Planning reference: 20/01316/TEL56

We have undertaken an assessment into the proposed installation for the proposed 5G Mast (ref. CWL045) on Skimmingdish Lane, Bicester – 459216E / 224155N.

Aviation Impact Assessment of the Proposed 5G Mast (ref. CWL045) on Skimmingdish Lane, Bicester – 459216E / 224155N

Title: 215 PROPOSED SITE PLAN

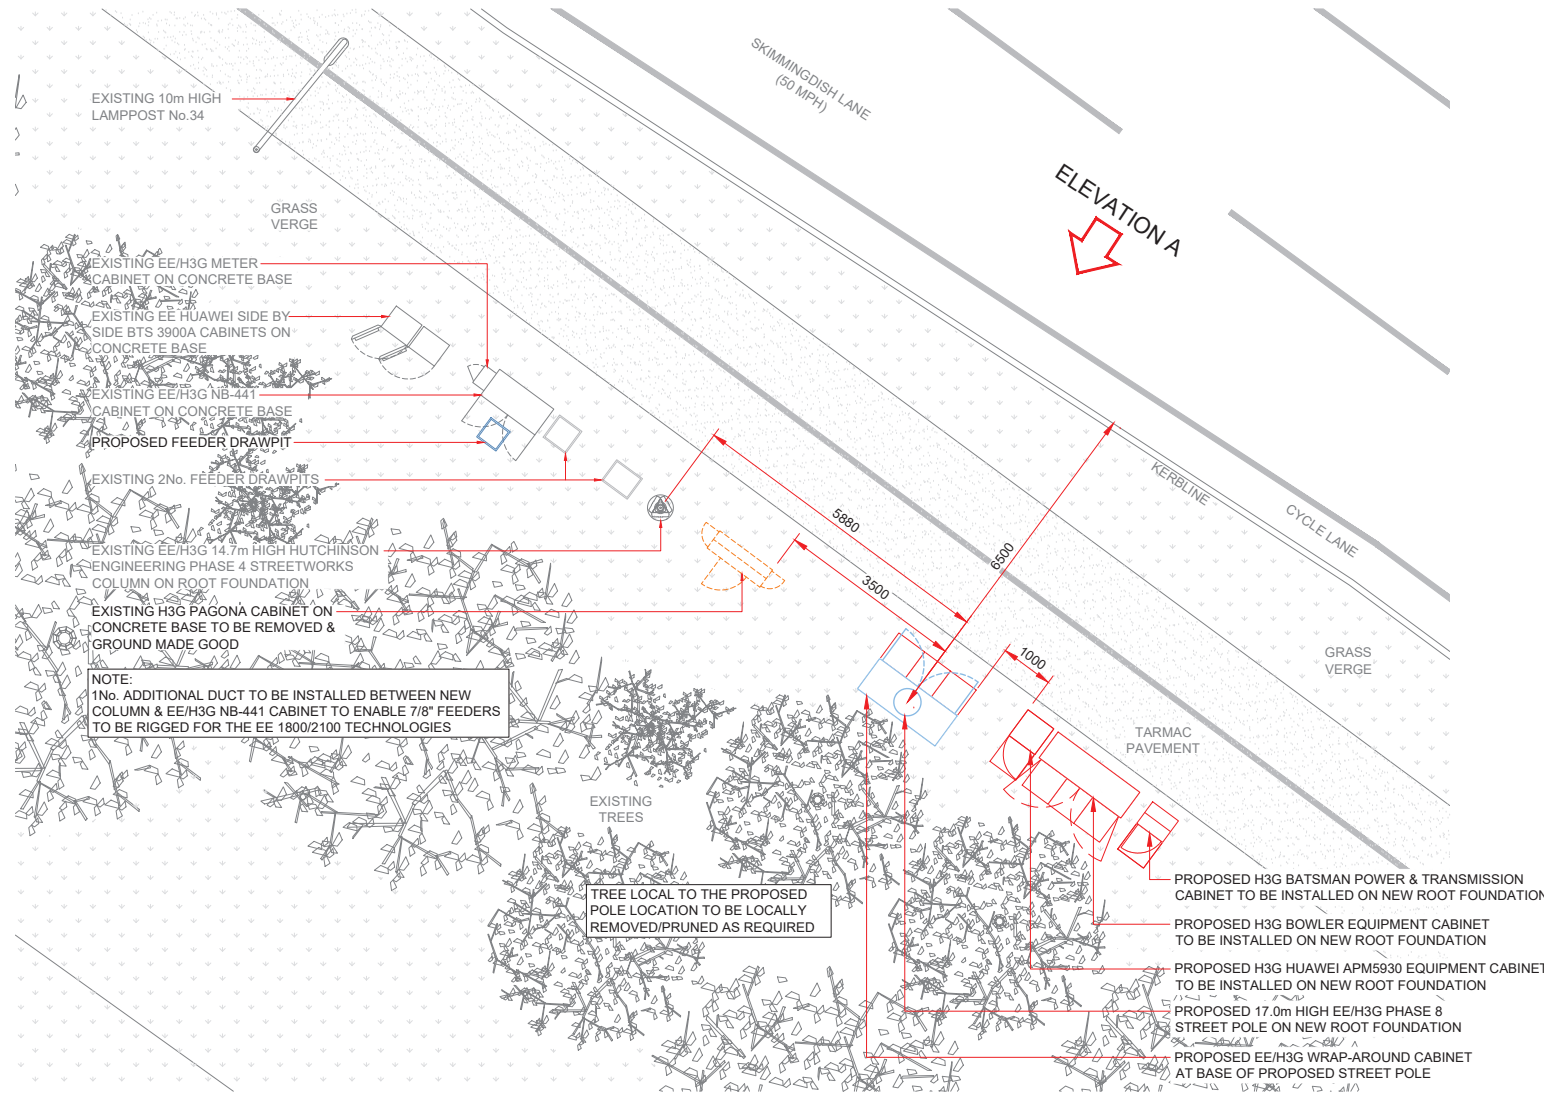
Runway 24 (direction 240°) is shown in green, no area of which, or any runway, should be inside the red hatched area originating from the proposed 5G mast site. The required obstacle free take-off climb surface (1:25 gradient) is shown in yellow.

Chapter 4 of CAP 168 details the assessment and treatment of obstacles and considers the take-off climb surface, which is an inclined plane beyond the end of the take-off run available, that must remain obstacle free. Para 4.8 sets the applicable requirement for an obstacle free climb out based on a 1:25 (4%) aircraft climb gradient. Given an obstacle of 16m in height, this equates to 400m horizontally in addition to the application of the mandatory 60m runway end safety requirement, thus, the distance of the mast from a runway must be 460m.

The result would be shortening the existing Runway 24 (direction 240°) by at least 150m, and a reduction in potential useable flying area within the South Western corner of the flying area, inside the airfield perimeter track, of around 200m. This would have a detrimental impact on existing and future aviation operations at Bicester airfield.
